Case Officer: Michael Sackey

Recommendation: Approval

Proposal: Discharge of Conditions 4 (Construction Traffic Management Plan), 5 (means of access), 6 (turning areas/parking), 7 (Arboricultural Method Statement), 8 (landscaping scheme) and 9 (acoustic insulation scheme) of 21/00026/F

TITLE
 NEW ACCESS
 LAYOUT
 & DETAILS

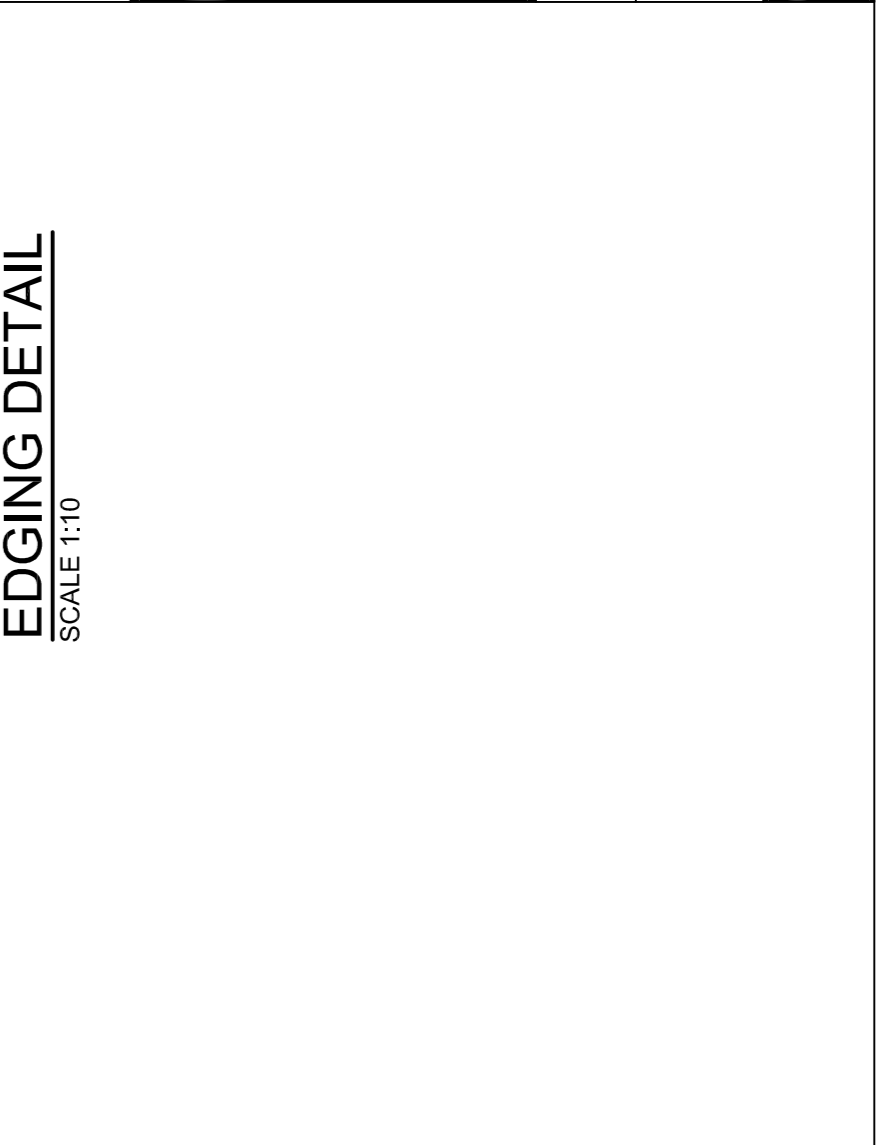
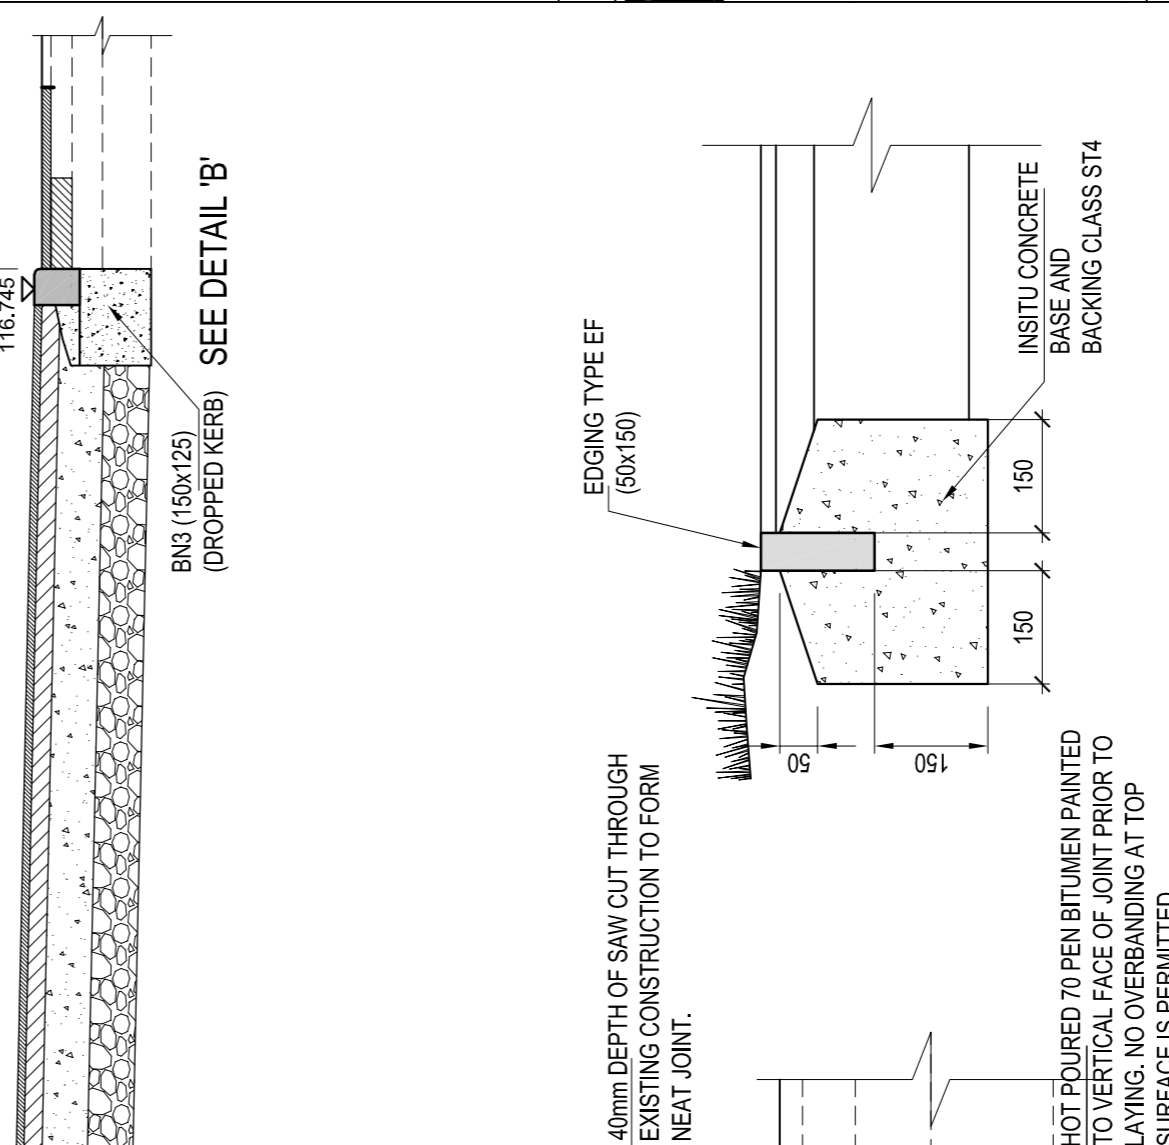
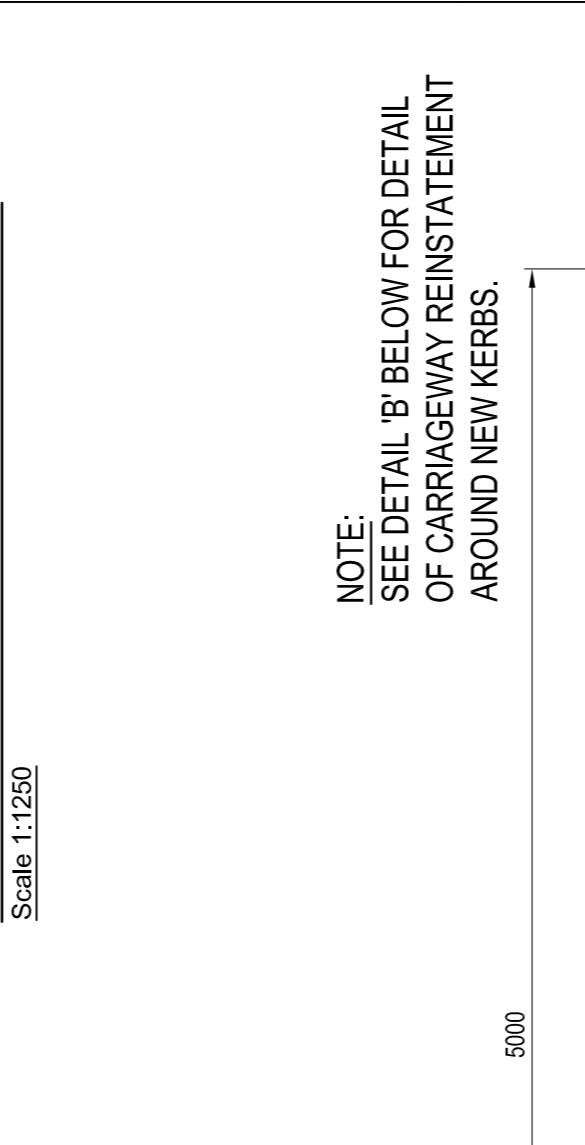
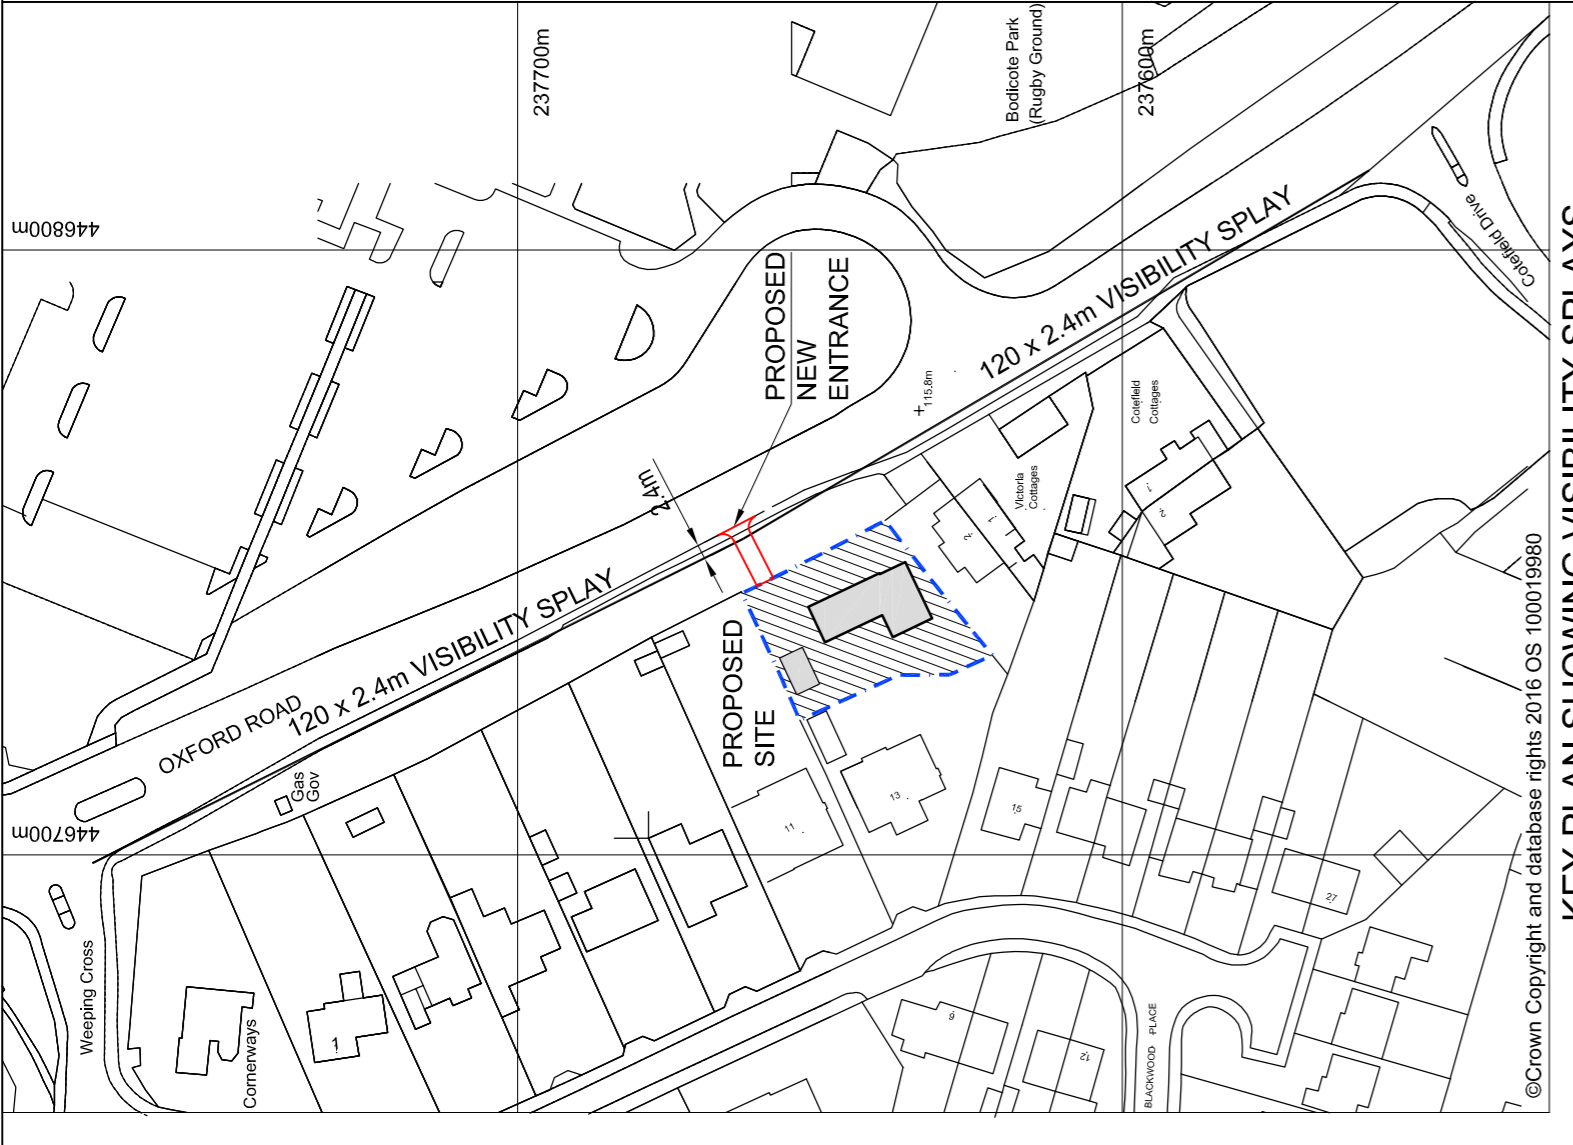
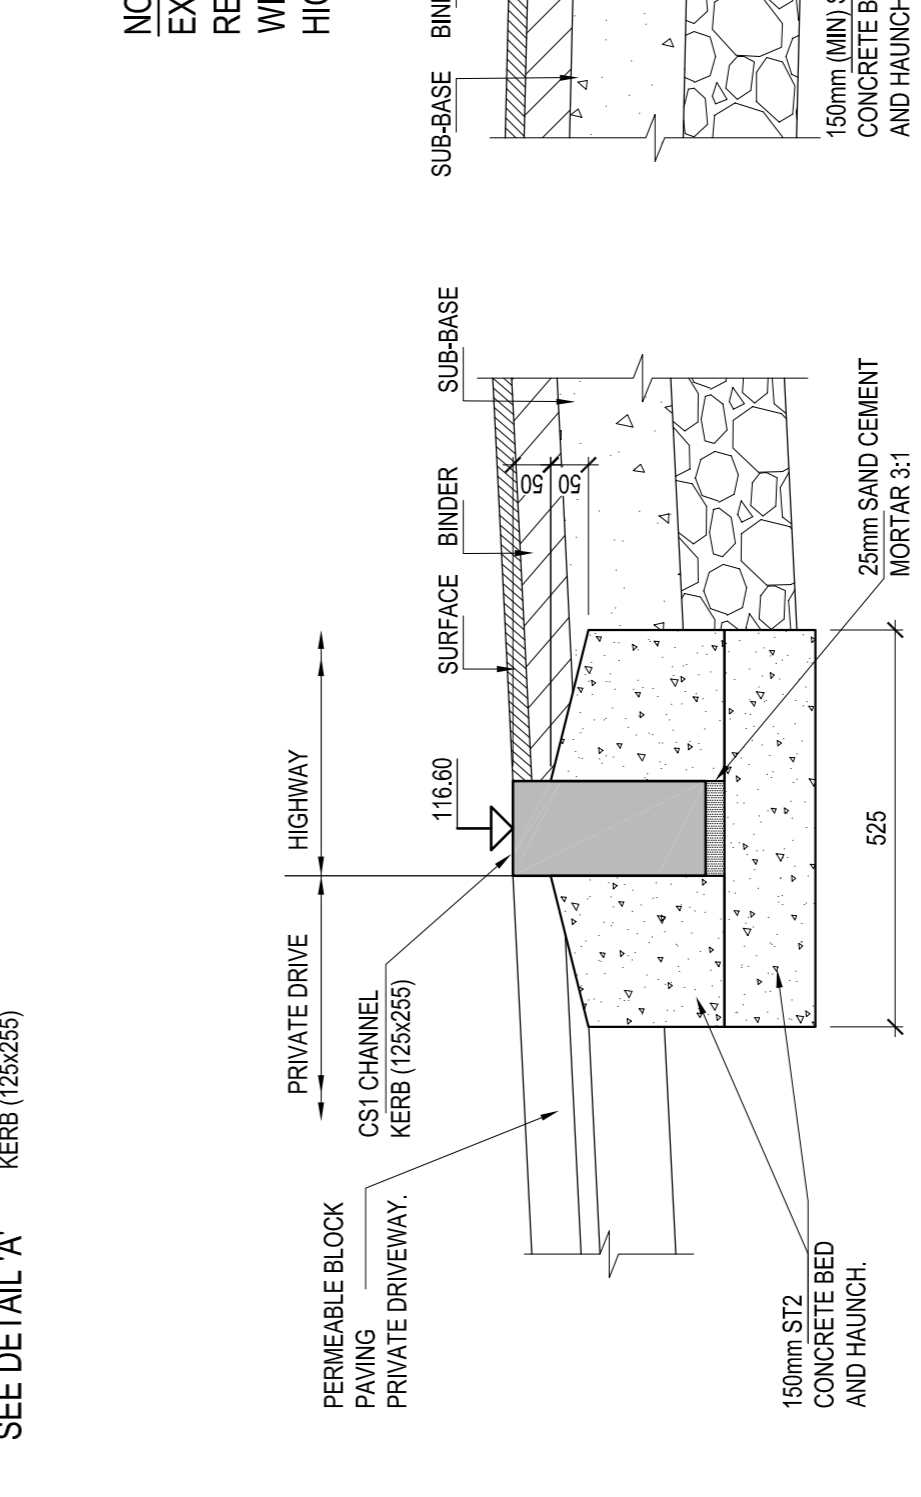
Condition 5: Means of Access

- Proposed tree removal, 2 of which belong to OCC. If the CDC or developer has not done so already, an OCC tree officer should be contacted to ensure this is acceptable and the trees are not protected.
- Subject to licensing and agreements.

A plan has been submitted illustrating full details of the means of access between the land and the highway, including, position, layout, construction, drainage and vision splays reference “60 Rev P2”. Having regards to the comments of the Highways Officer, the details and plan provided are considered acceptable.
